Case Officer: Rebekah Morgan

Recommendation: Approve

Applicant: Morley Stores

Proposal: Discharge of conditions 4 (means of access), 5 (turning area details), 6 (detailed scheme for the surface water and foul sewage drainage) and 9 (Construction Environment Management Plan) of 20/02139/F

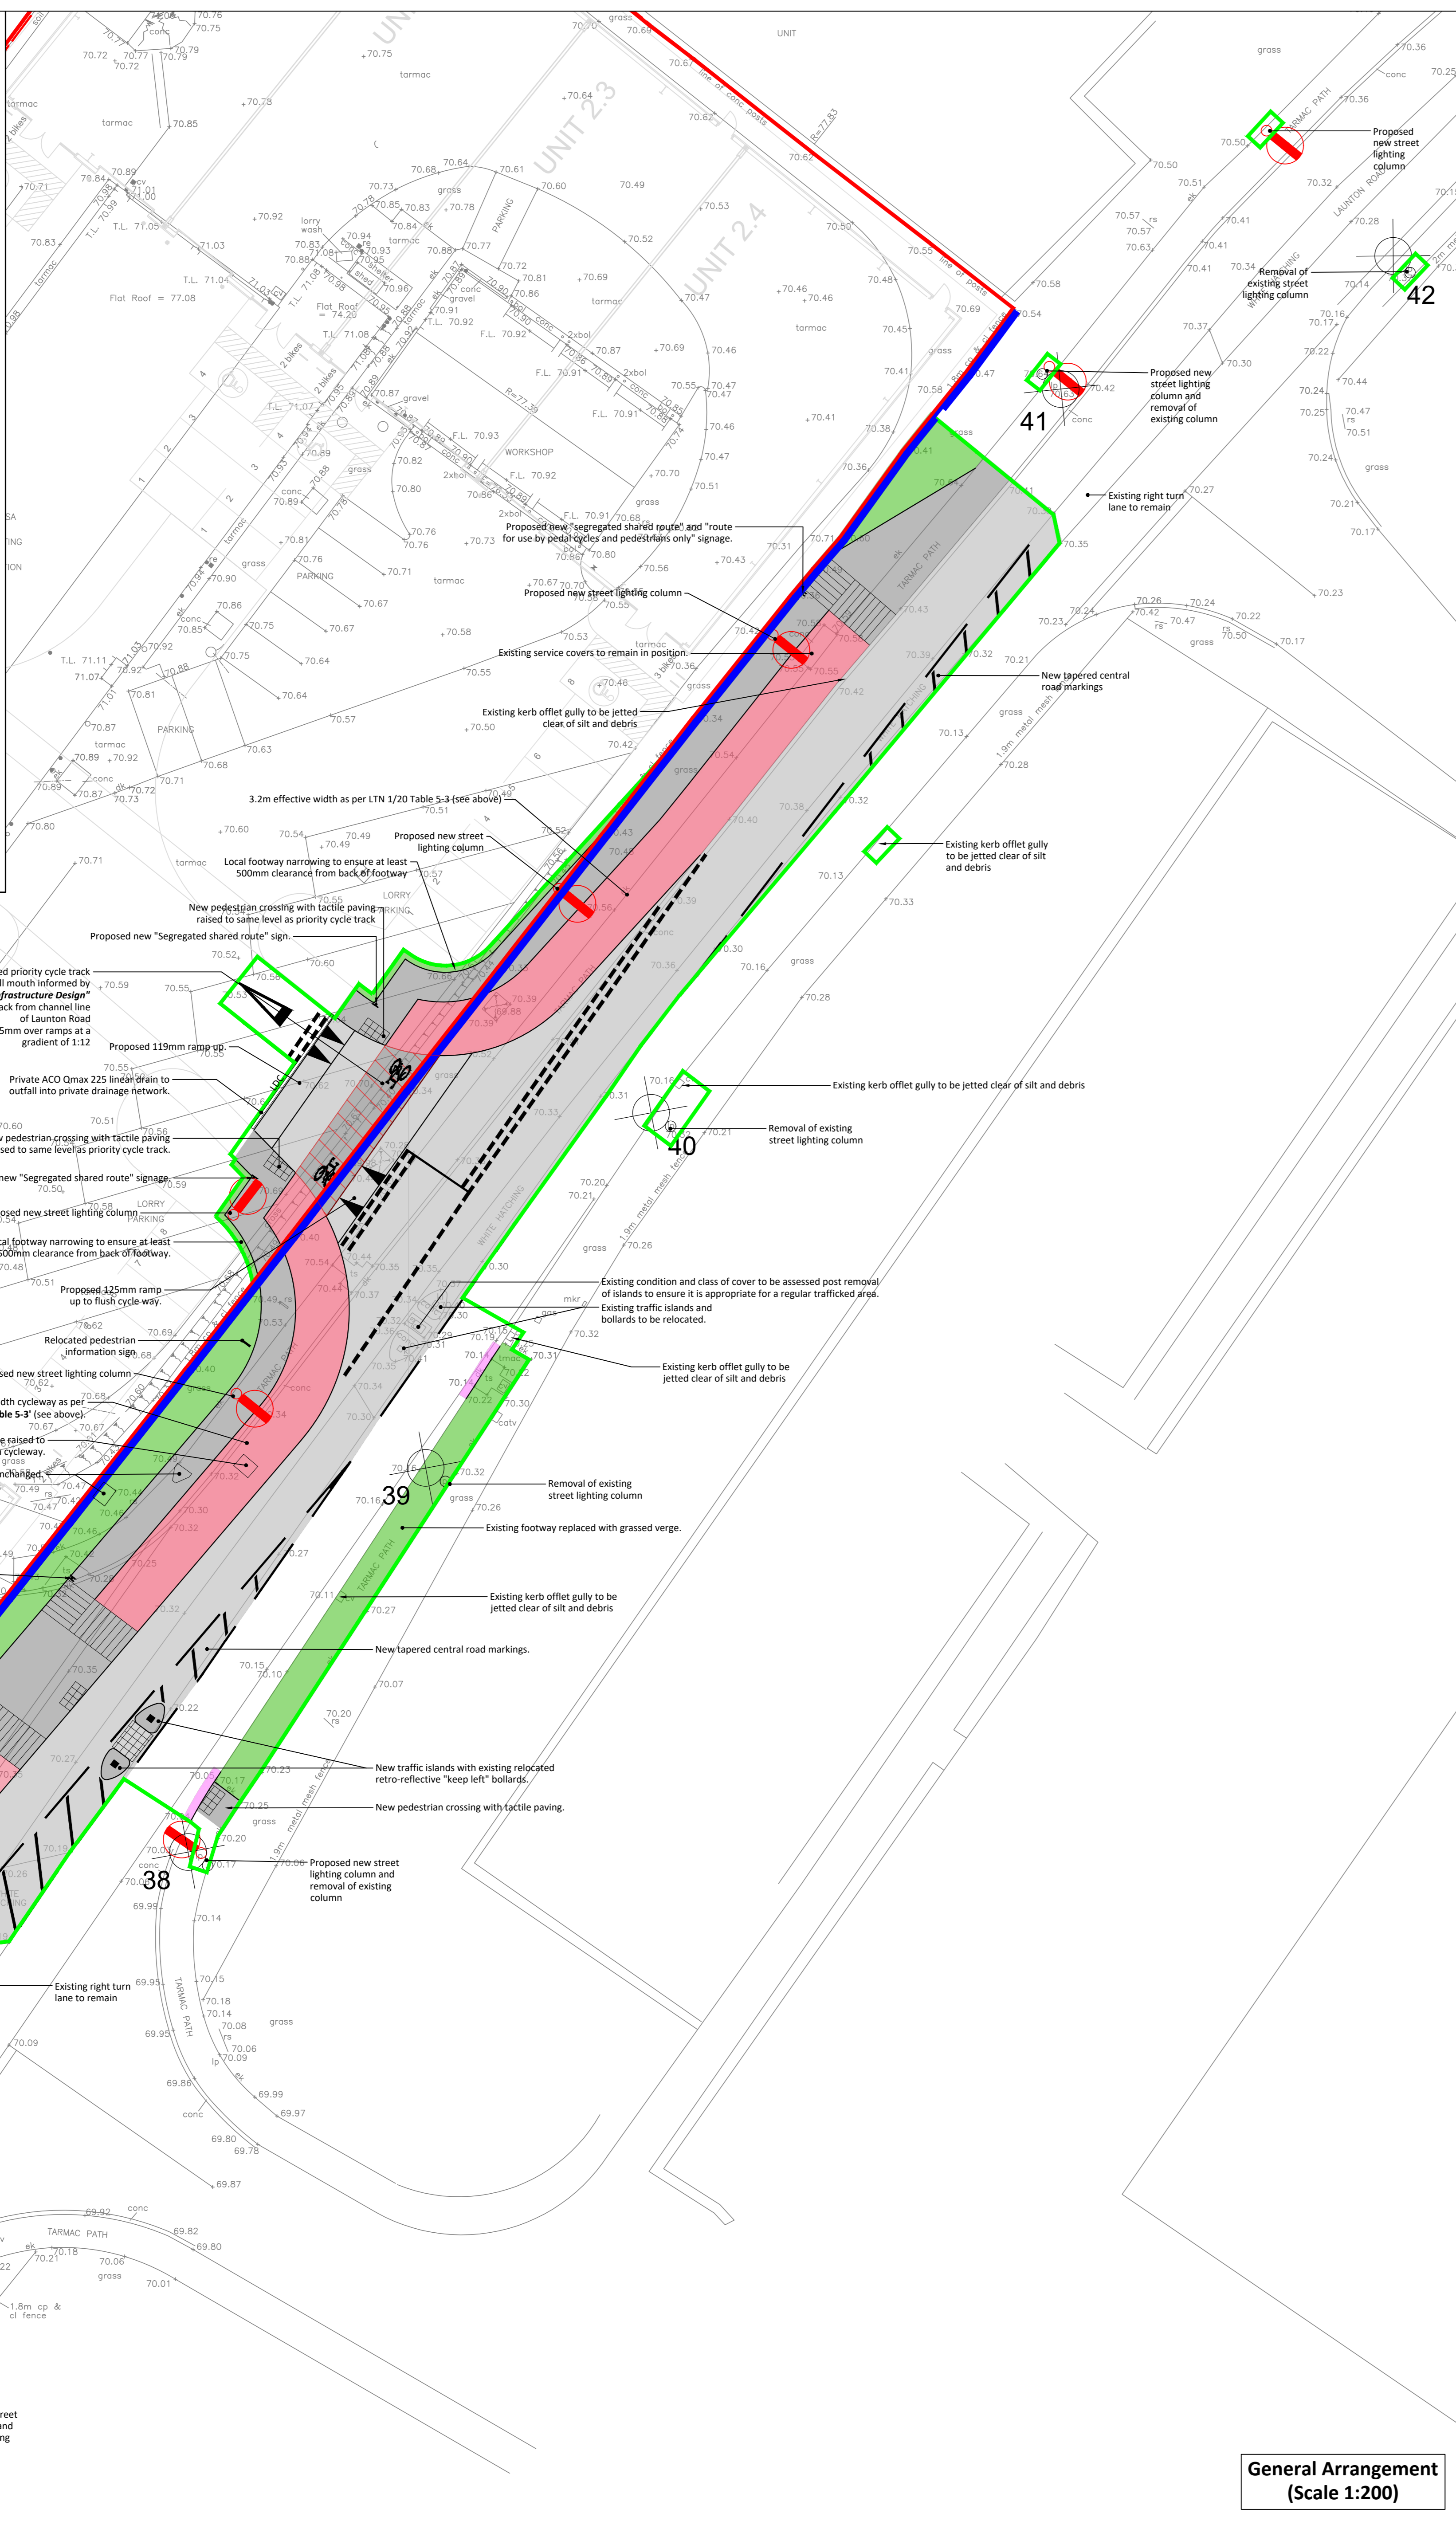
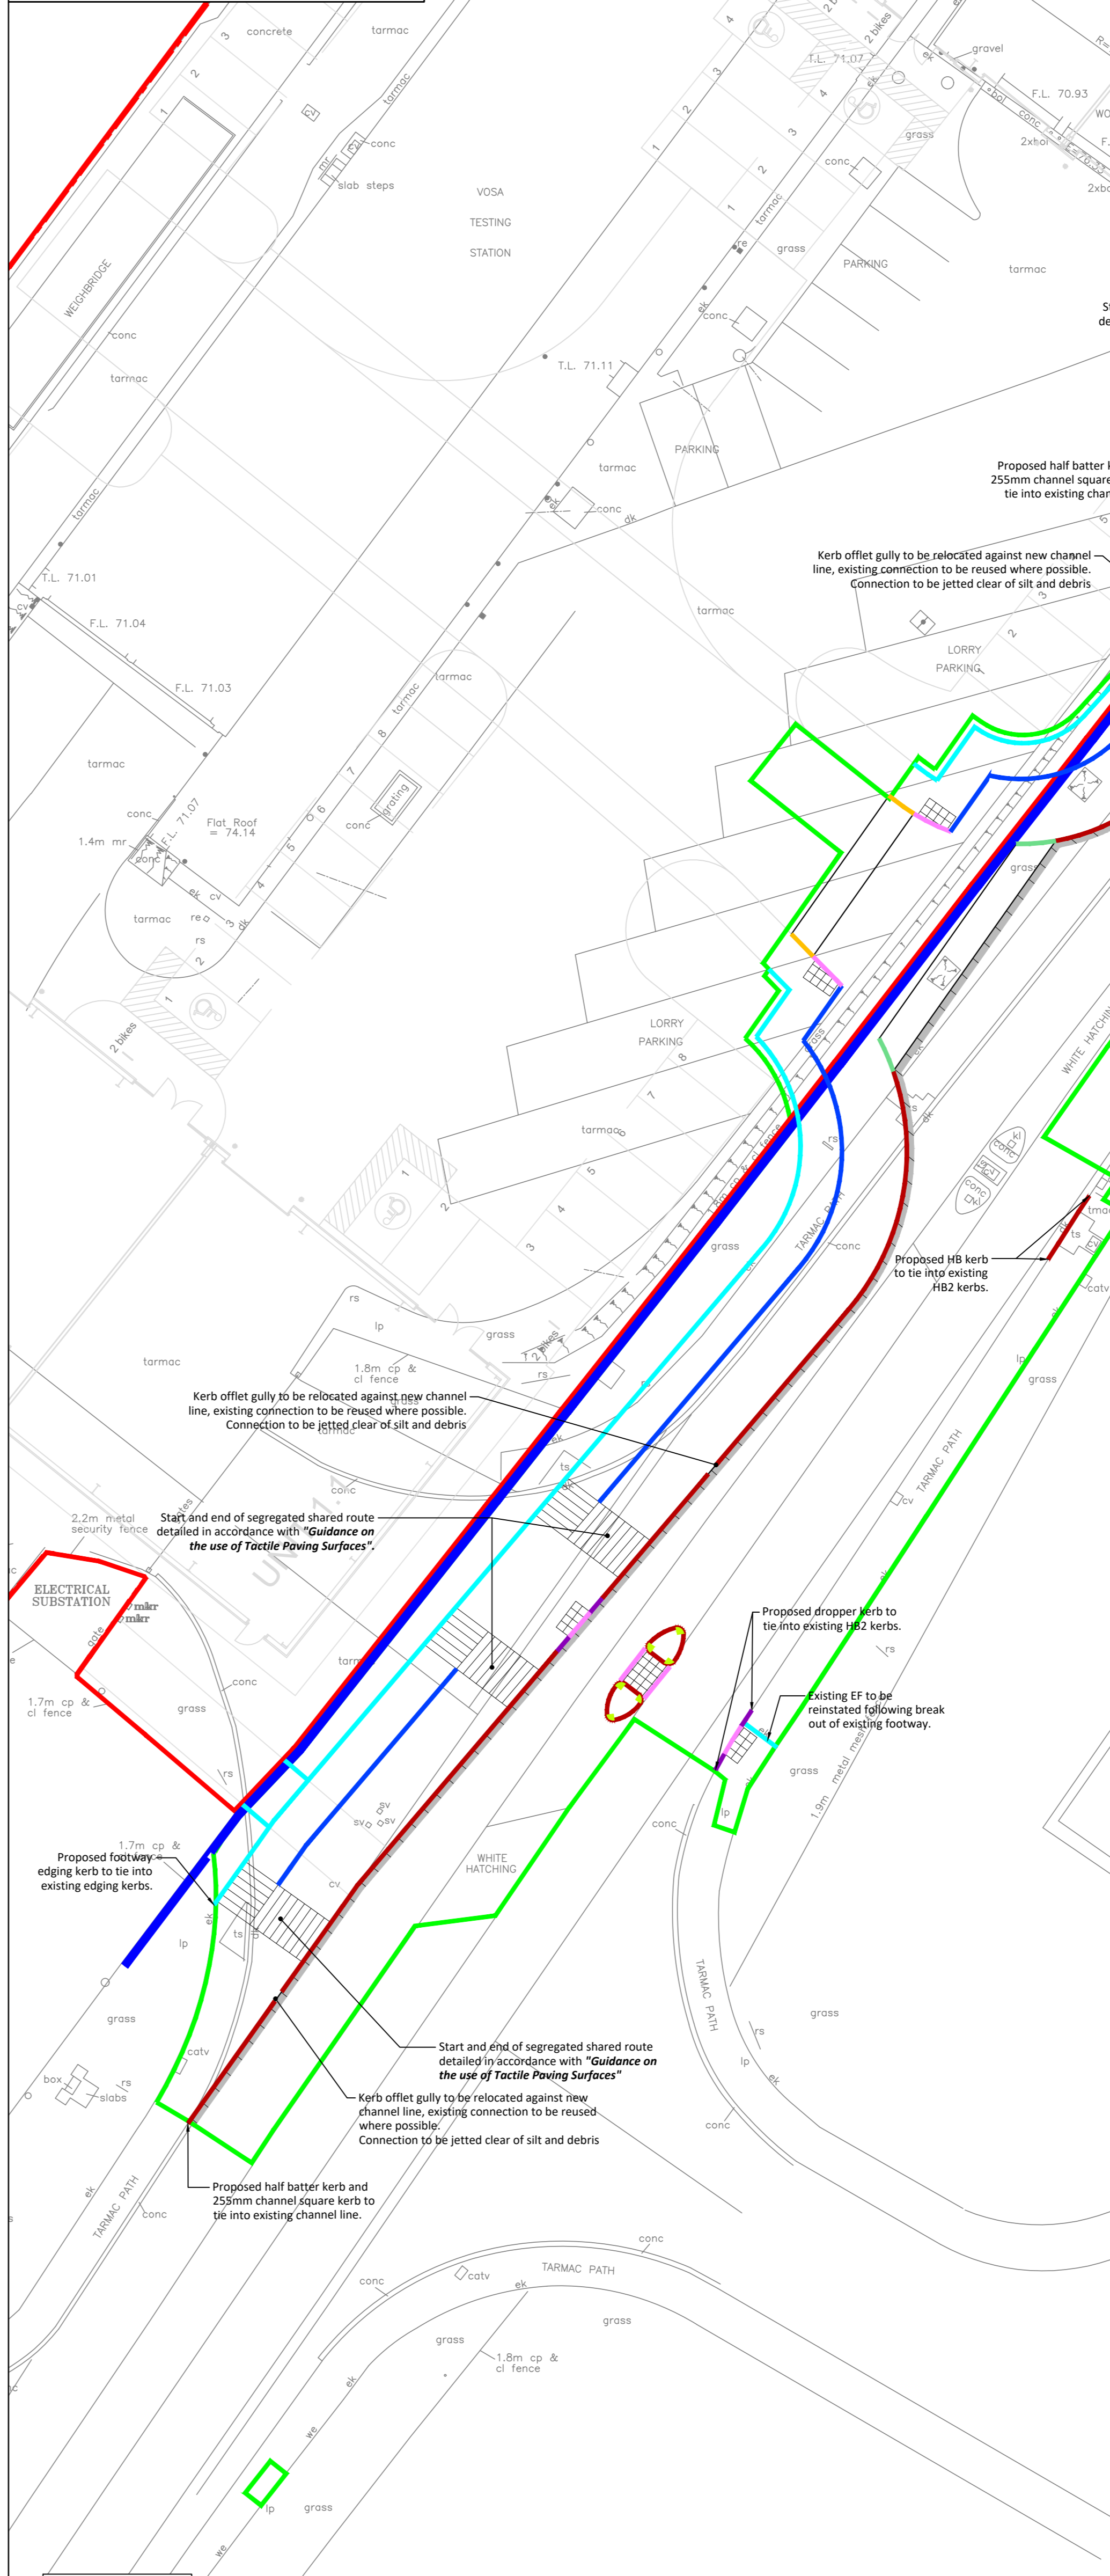
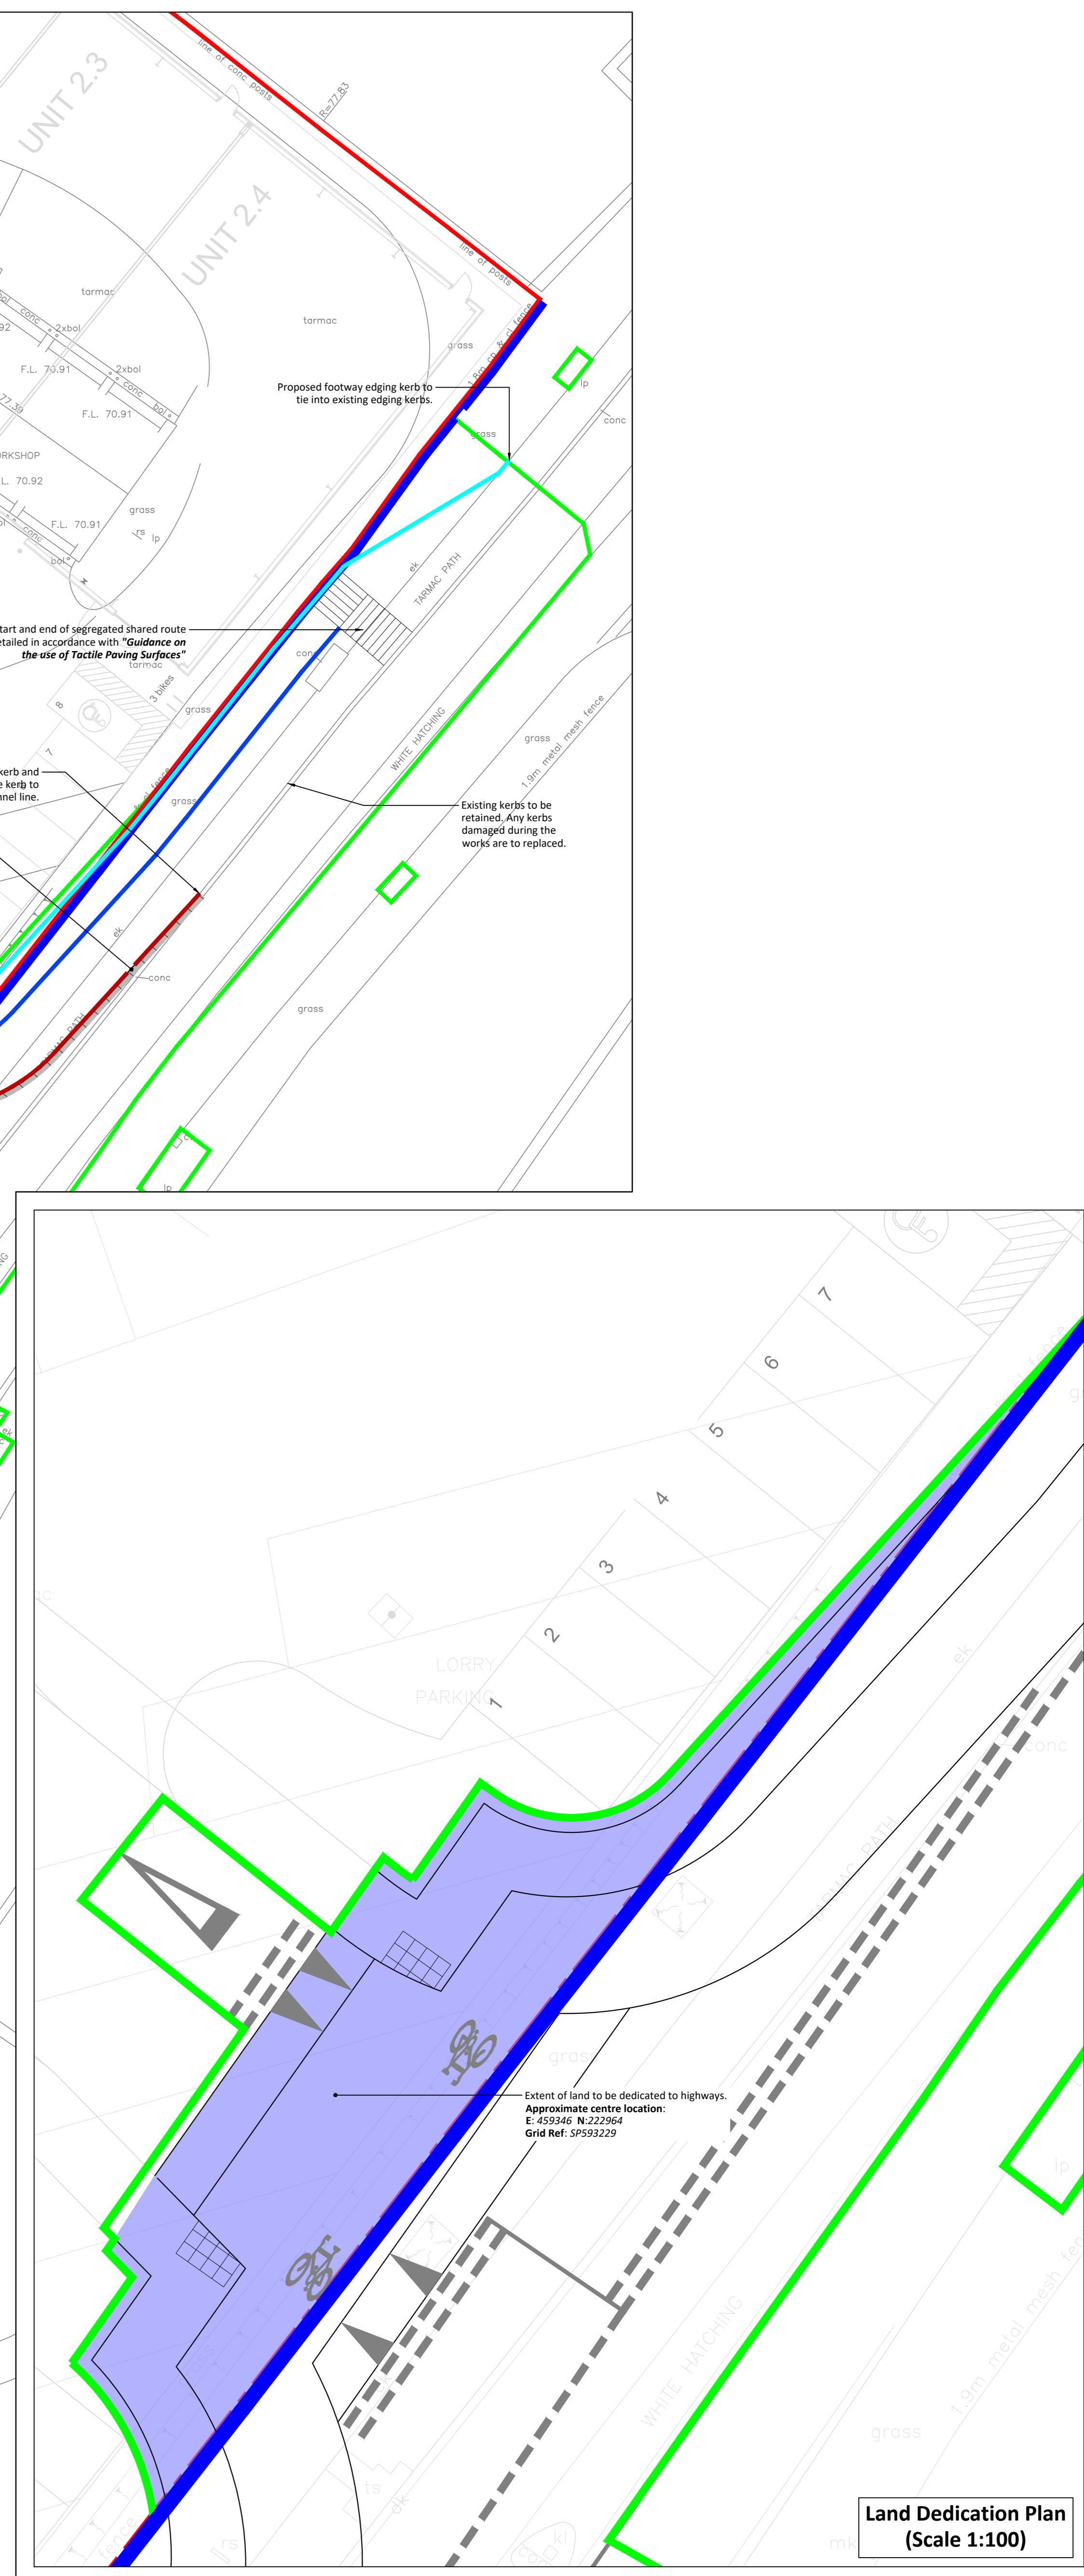
Condition 4 - Since our previous response to application no. 20/02139/F, it has become clear that the means of access to the site should be fully LTN1/20 compliant. This entails a fully segregated cycle/pedestrian path along the frontage of the site including a 3m wide cycle path, 2m wide footpath and fully set back crossing facility. The applicant has submitted updated drawings which show an LTN1/20 compliant solution to the access.

The ghost right turn lane has been removed. On balance, the benefits to cyclists and pedestrians were considered to outweigh any potential disruptions to the flow of traffic which remain unlikely. The proposals are now considered LTN1/20 compliant and as such, OCC do not object to the discharge of condition 4 (means of access).

- 5.1. Condition 4 – The proposed details have been amended during the application in response to the initial comments received from OCC Highway Officers. The amended drawings now include a fully segregated cycle/pedestrian path along the frontage of the site including a 3m wide cycle path, 2m wide footpath and fully set back crossing facility, which will be in full accordance with LTN 1/20.

The ghost right turn lane was removed from the scheme. OCC highway officers have advised that on balance, the benefits to cyclists and pedestrians were considered to outweigh any potential disruptions to the flow of traffic which remain unlikely.

OCC Highway officers have confirmed that the amended details set out a proposed scheme that they consider comply fully with the guidance set out in LTN 1/20.

The proposed access details are considered to be acceptable, and it is therefore recommended the condition is discharged.
